**Sydney Children's Hospital Stage 1 and
Children's Comprehensive Cancer Centre (SSD-10831778)
Response to submissions**

Attachment 1

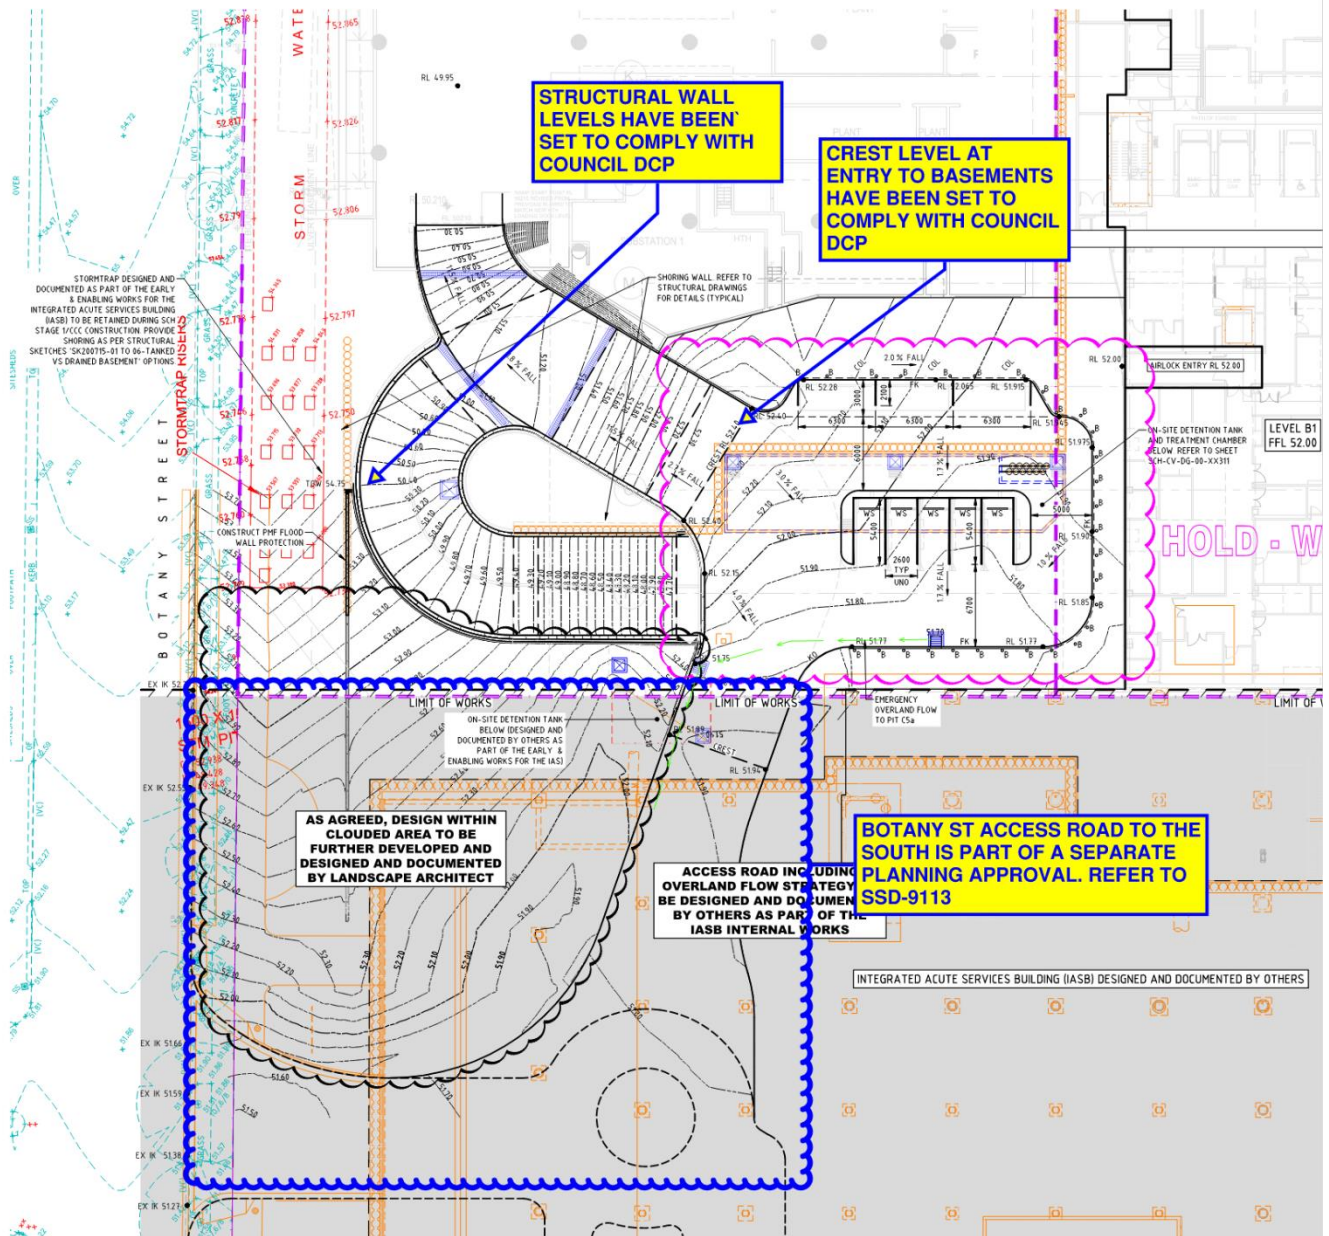
- Provide updated information on flood protection to address concerns raised by the Biodiversity and Conservation Branch, including:
 - consideration of incorporation of a separate flood barrier where appropriate, with further information on the design of the barrier and updated modelling.
 - a table or plan demonstrating the flood levels and finished floor levels at all entrances including carpark entrances and measures to protect against ingress of floodwaters.

Figure 10 General Arrangement Plan - Level B1 south

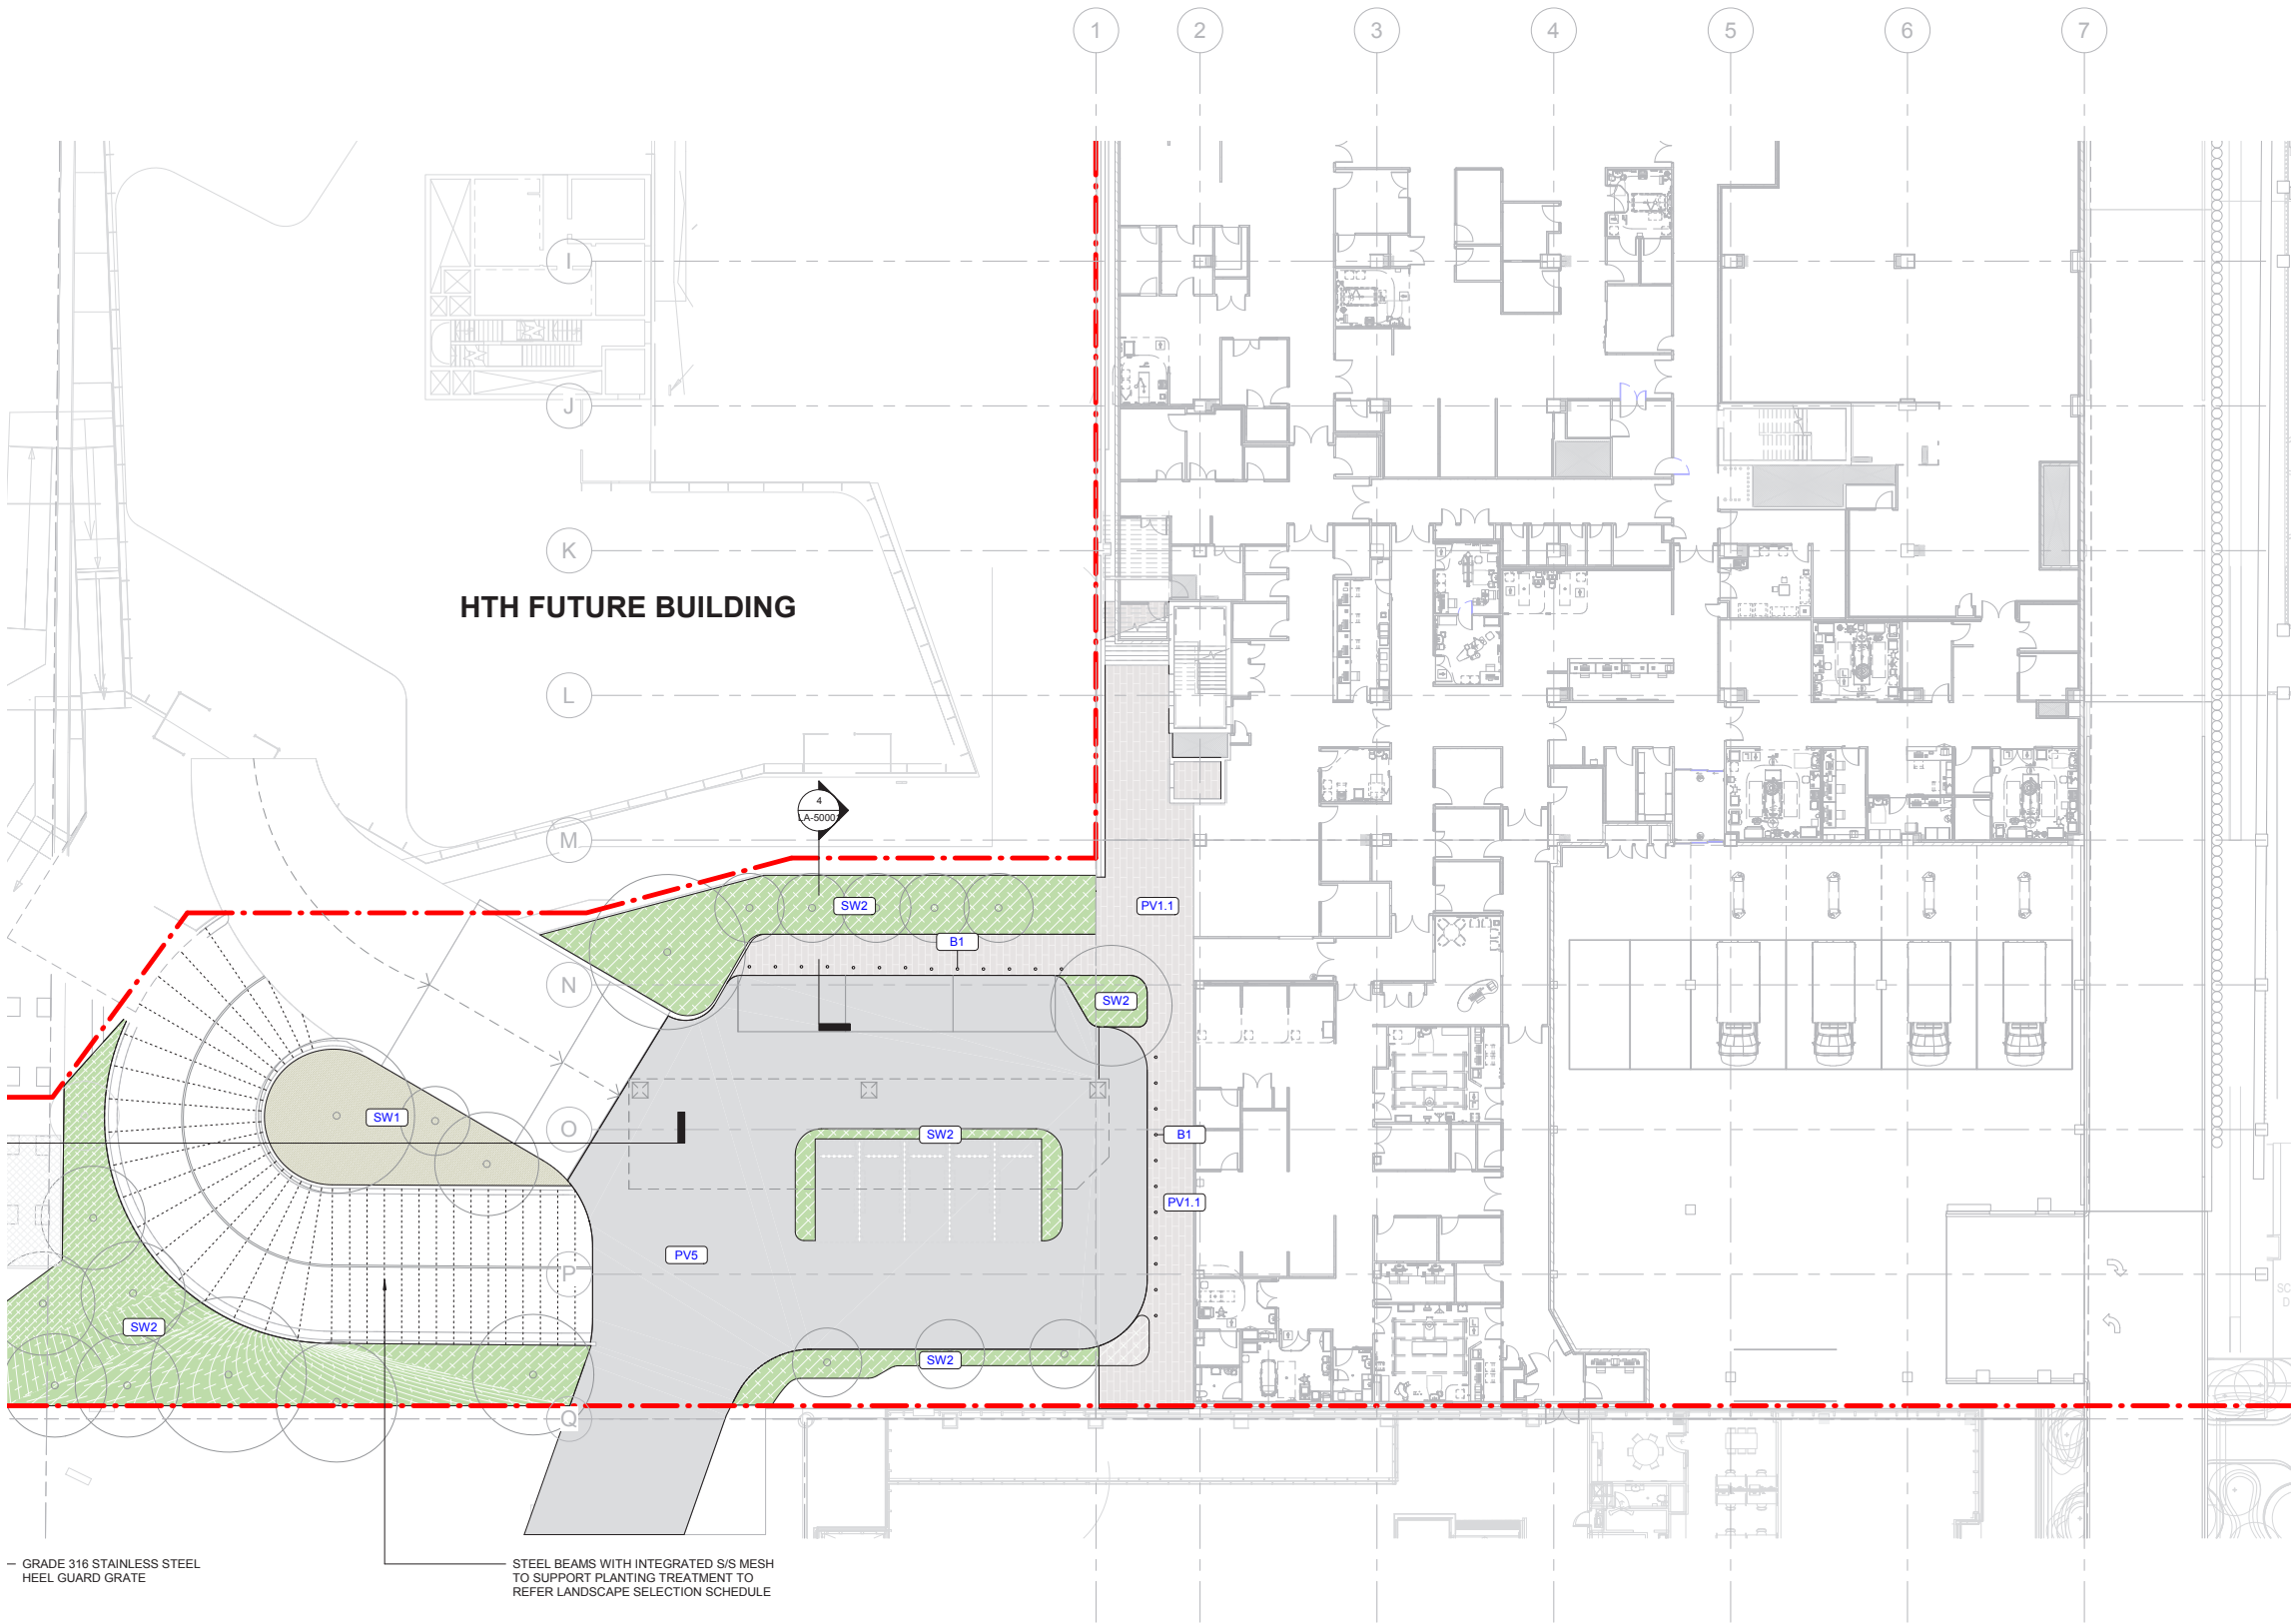
- Give further consideration to the design of the emergency department drop-off area to ensure clear, direct and intuitive access to the emergency department reception. Provide further details, including plans and elevations, detailing treatment of the area and images to demonstrate the amenity of the space.
